From: Iain Osenton <iain.osenton@cherwell-dc.gov.uk>
Sent: Wednesday, October 23, 2019 4:34 PM
To: Planning <Planning@Cherwell-DC.gov.uk>
Cc: dcregistration <dcregistration@Cherwell-DC.gov.uk>; George Smith <George.Smith@Cherwell-DC.gov.uk>
Subject: 19/02075/F - CDC Arboriculture comments

Regarding the above referenced application, from desk based assessment.

ECO 3 - TREE ISSUES AT THE OLD VICARAGE, FRINGFORD ROAD, CAVERSFIELD

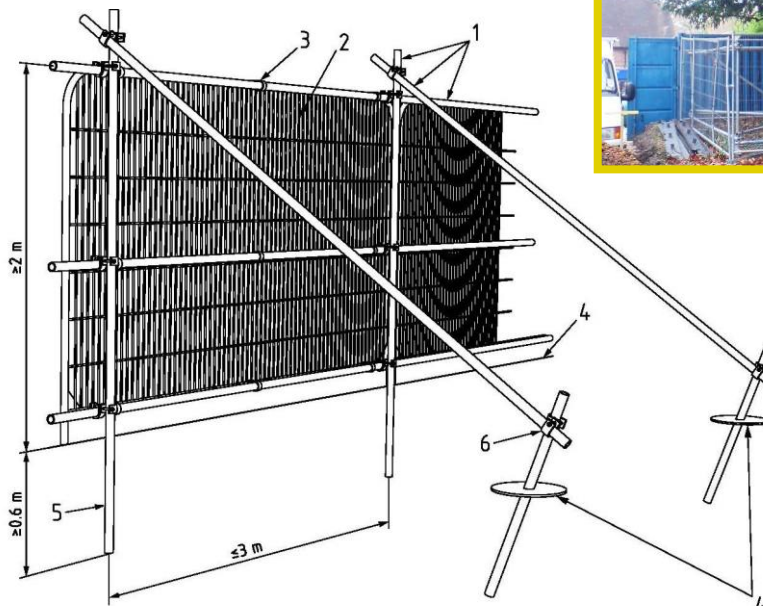
There are 3 groups which appear to consist of 7 trees designated for removal under the current Arboricultural Implications report. I agree with the report in that these trees offer little amenity outside of the site, and their removal will not be of detriment to the locality. These removals however should be proportionately mitigated with replanting throughout the site, not just limited to within gardens. I would suggest a replanting plan should be submitted before removals are permitted.

There also appears to be a lack of screening between existing properties to the east of the site, and the proposed dwellings. There appears to be some proposed planting within the rear gardens of the properties however this isn't guaranteed to be sustainable.

Site Plan
AS PROPOSED
Scale 1:200

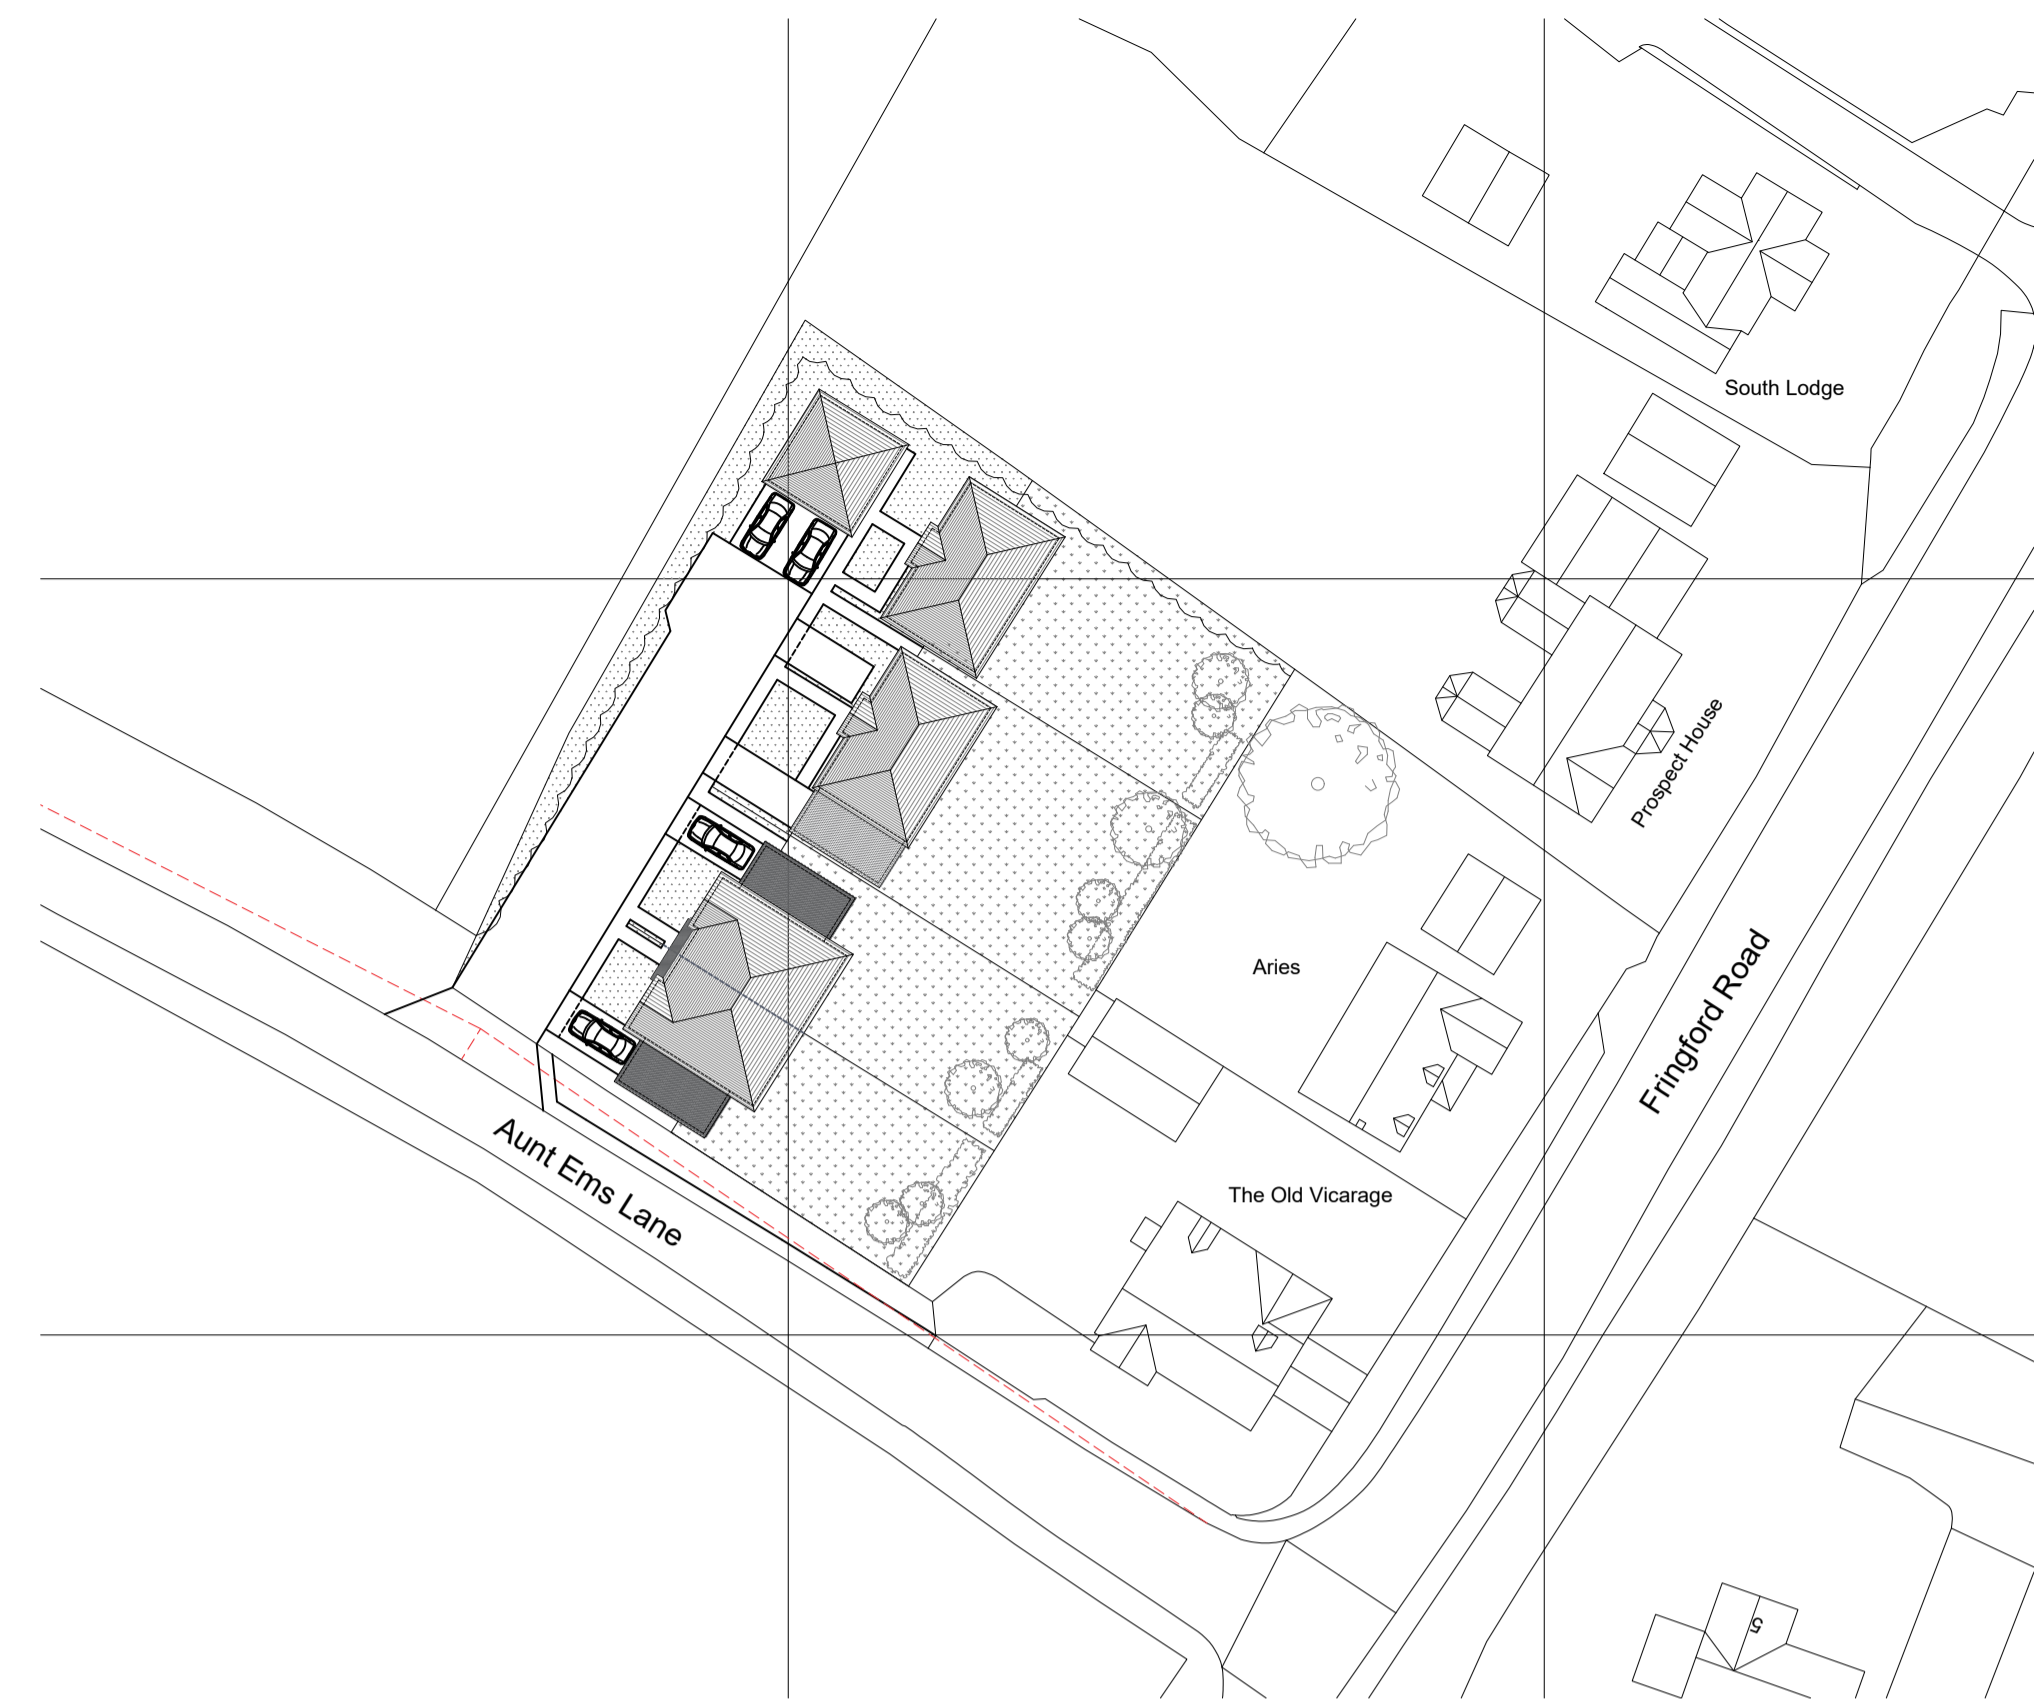
I do hold concerns for the proximity of the north most plot, it appears to be extremely close to a coniferous hedge which will no doubt create future management pressures due to shading. Has there been any discussion regarding management of this hedge? Alternatively I would object to a plot being so close.
